**ADC Planning Consultation
Conservation/Design Officer Response**

Application Number	Y/72/17/HH
Address	Berri Court Main Road Yapton BN18 0ED
Description	Boundary fencing. This application affects Character & Appearance of the Main Road/Church Road, Yapton, Conservation Area.
Case Officer	Mr R Leal
Date	19 th December 2017

Street Elevation (B2132) @ 1:200

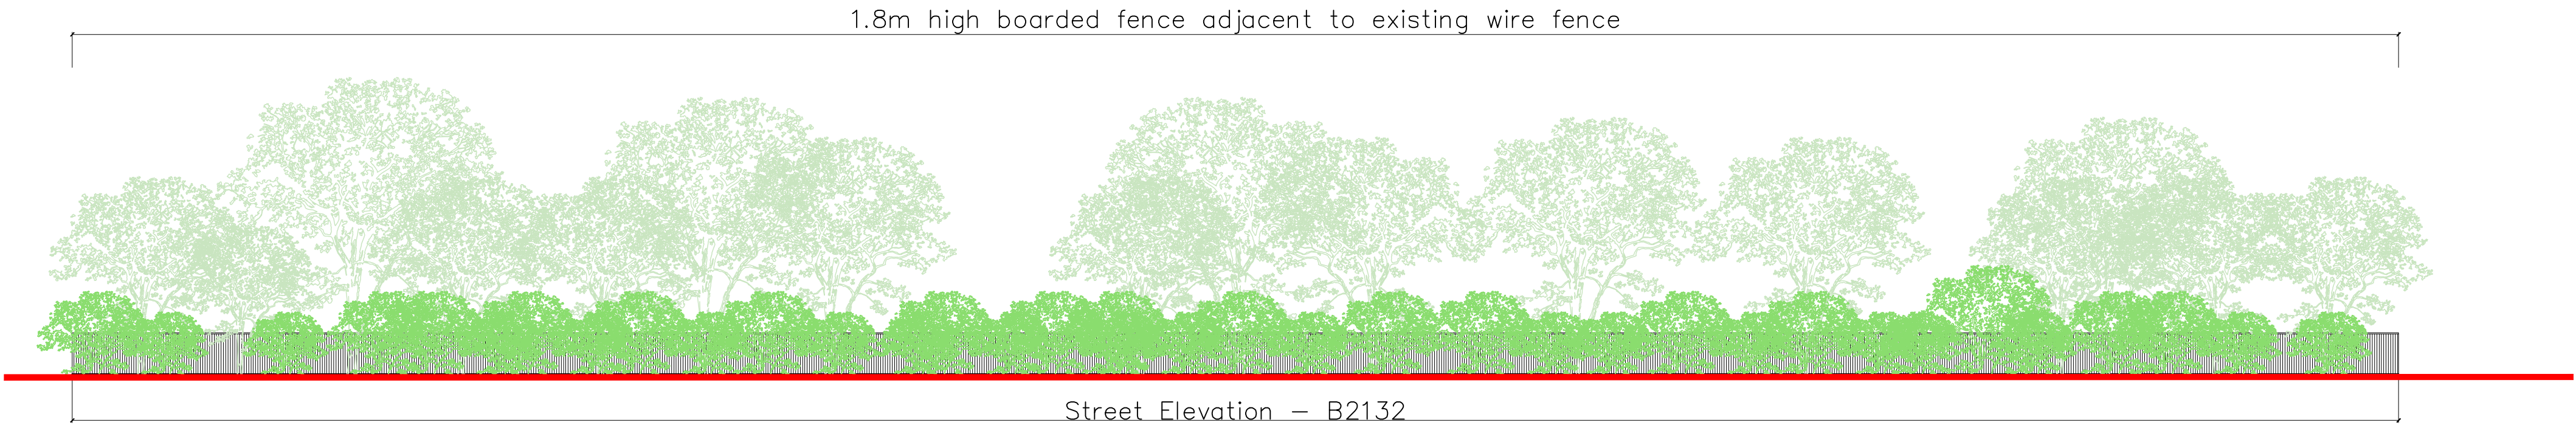
The proposal is to erect a boundary fence of approx. 1,800mm, close boarded timber, to the entire site.

In general terms, there are insufficient details to ascertain the nature and installation of the fence, including the disturbance of a number of mature trees within the site. The Heritage Statement is incomplete, and would not meet the necessary requirements to properly consider this application.

However, the site is prominent within the Conservation Area, and the visual intrusion of any such fencing would not be supported. The site benefits from its original flint wall (curtilage of a Listed Building), and any such proposed fence would have a detrimental effect on this element and would not be supported in principle.

It is recommended that this application be refused.
